Our Ref: FP/37/18/CLP
Your Ref:

Application for Lawful Development Certificate for a Proposed Use or Development

Development Lawful development certificate for a proposed rear conservatory.
Location 24 The Grove Felpham

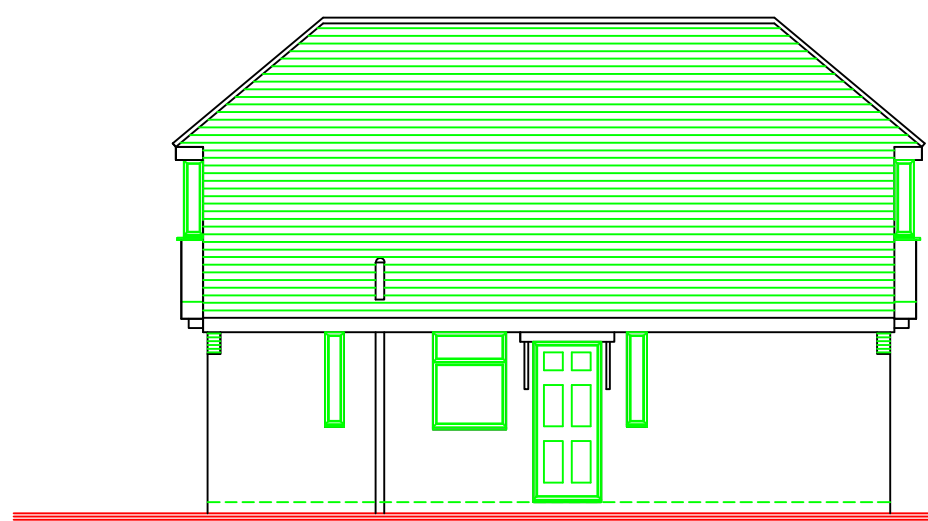
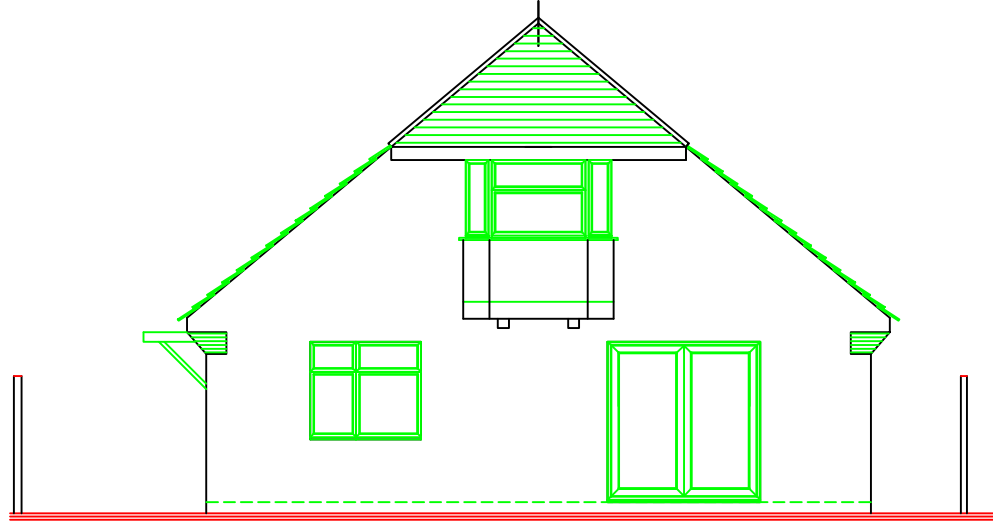
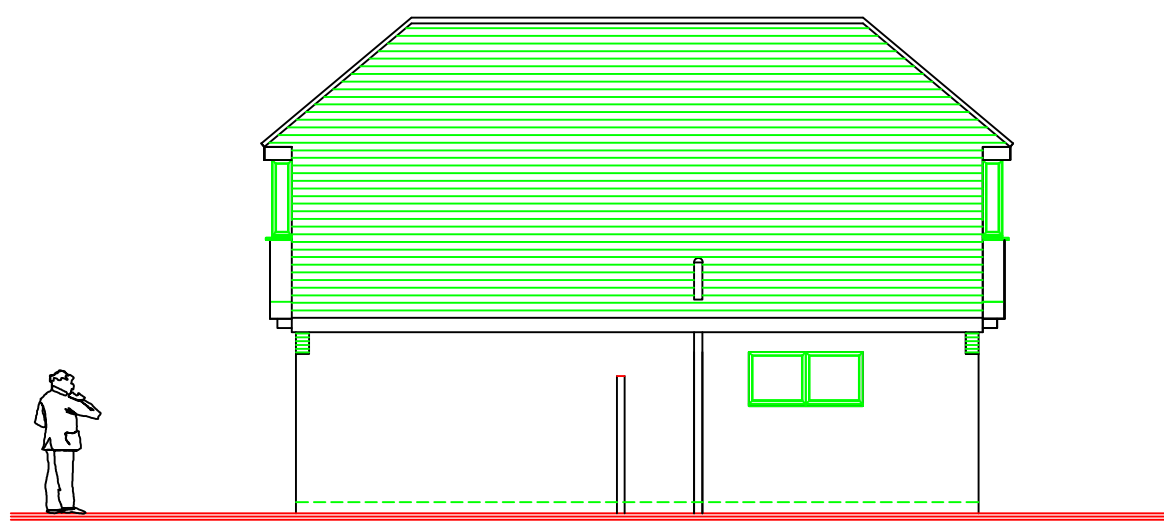
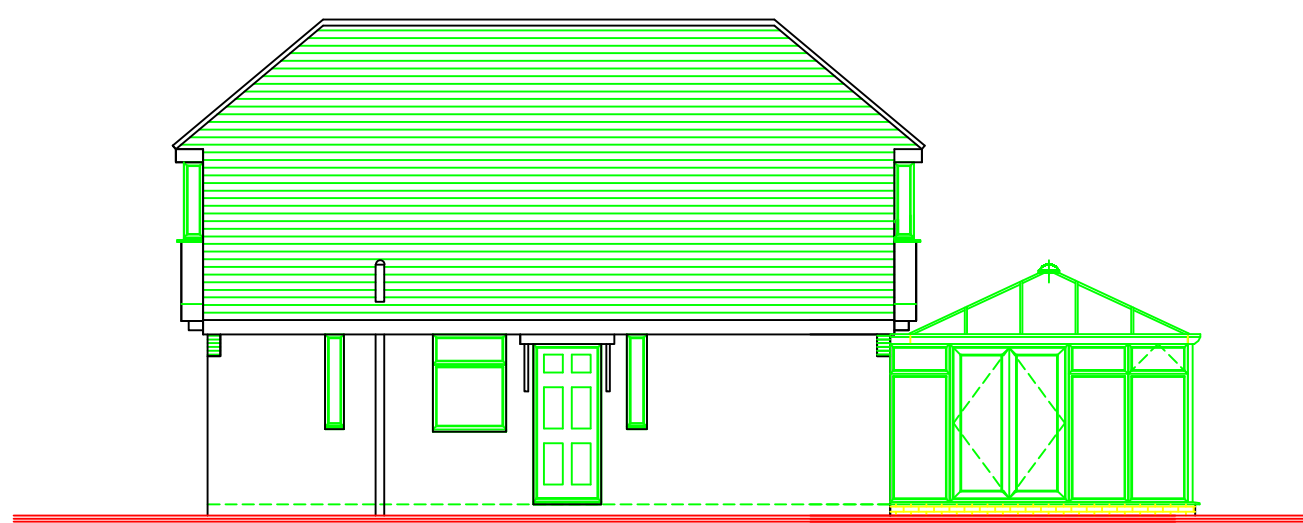
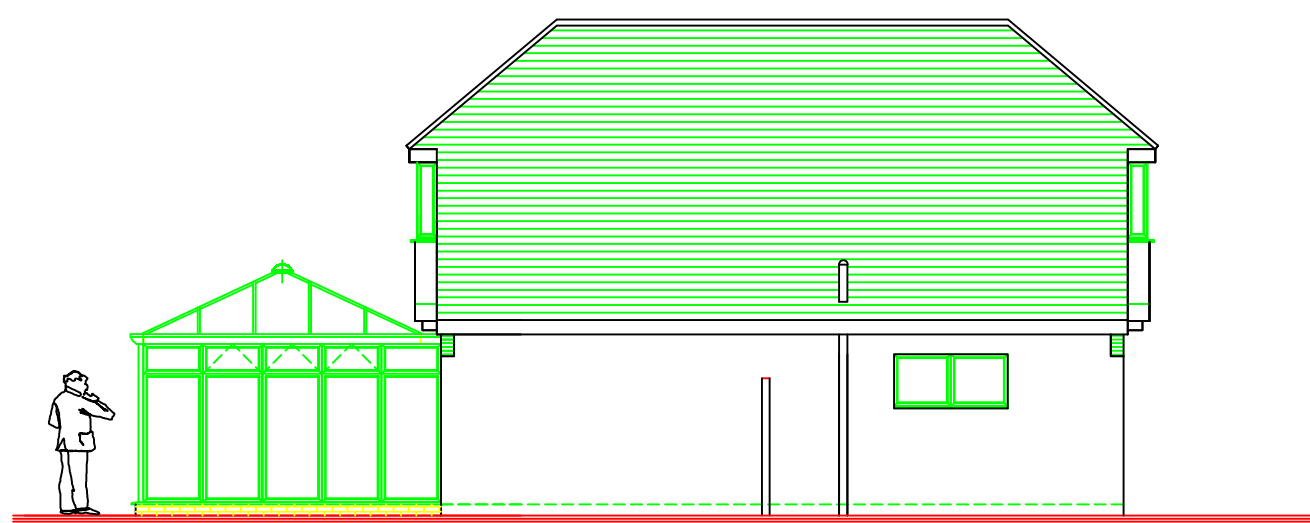
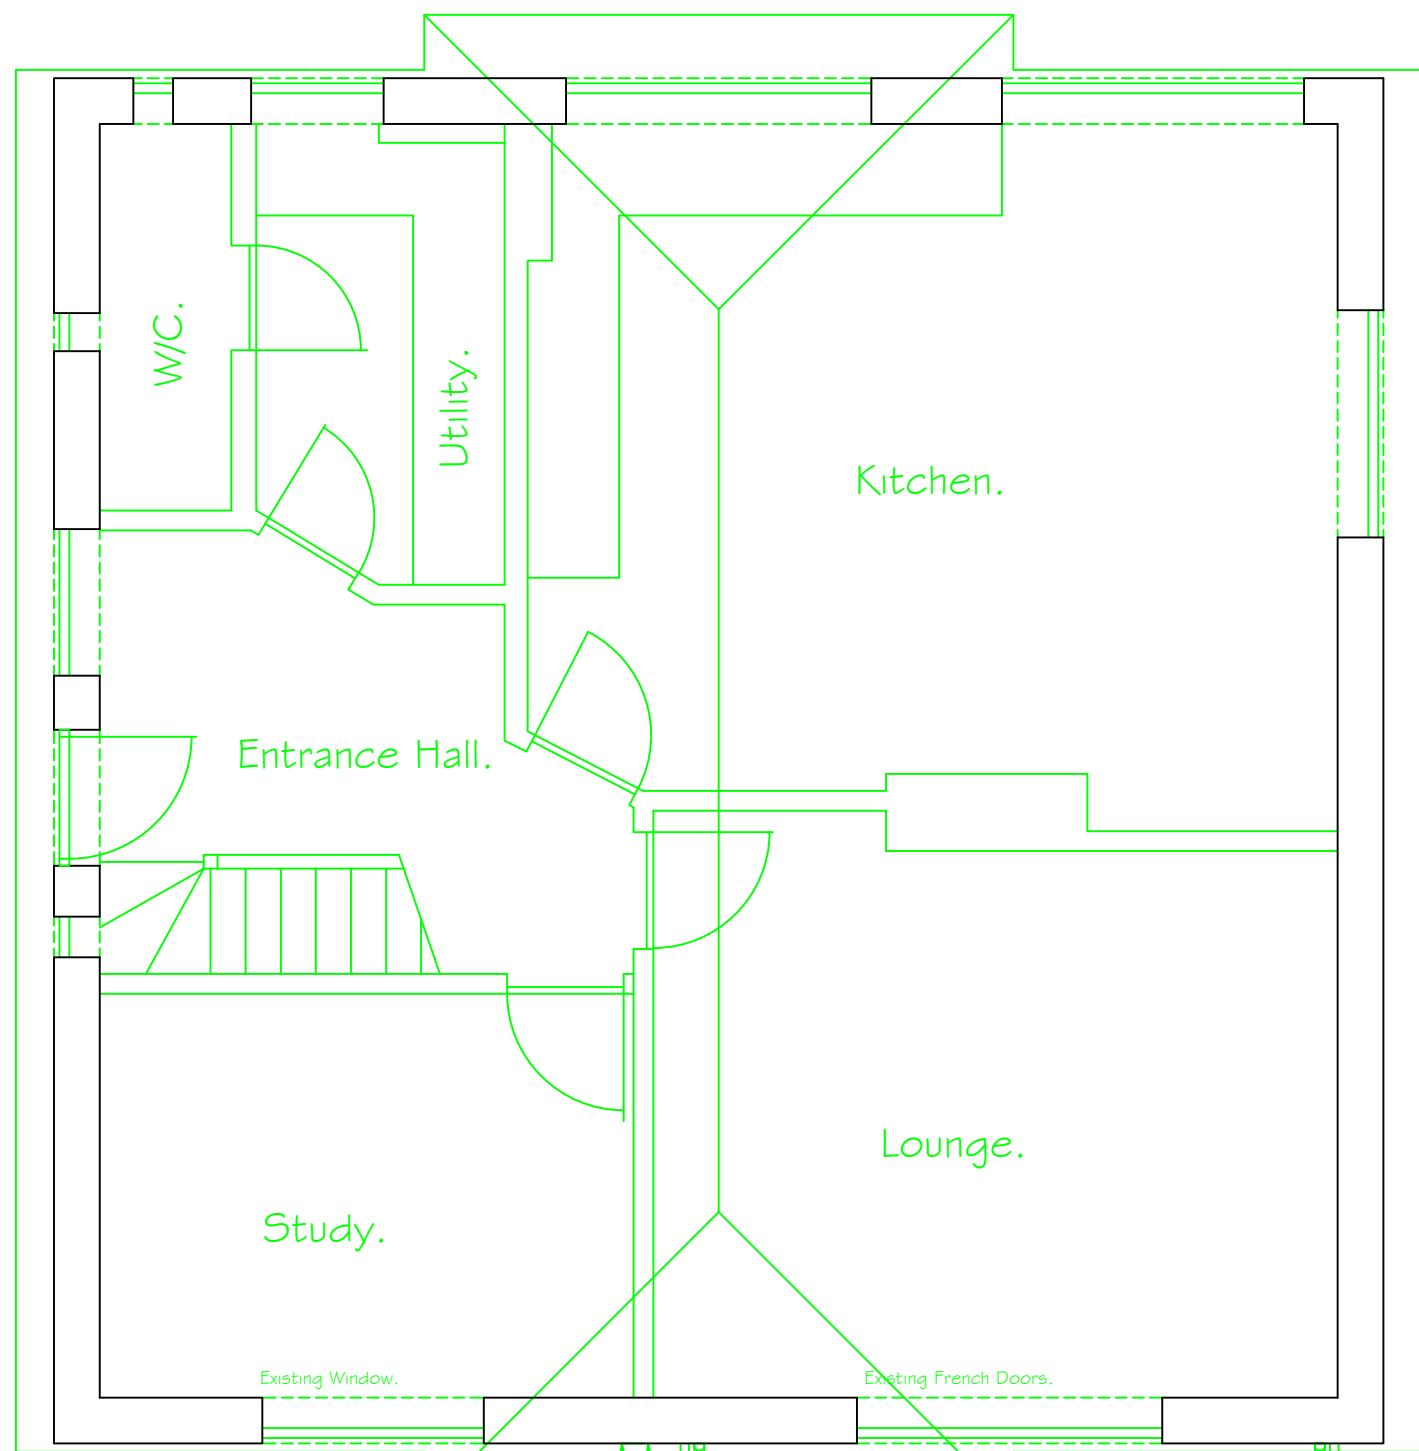
The existing and proposed side elevations and floor plans do not accord. Please amend accordingly.
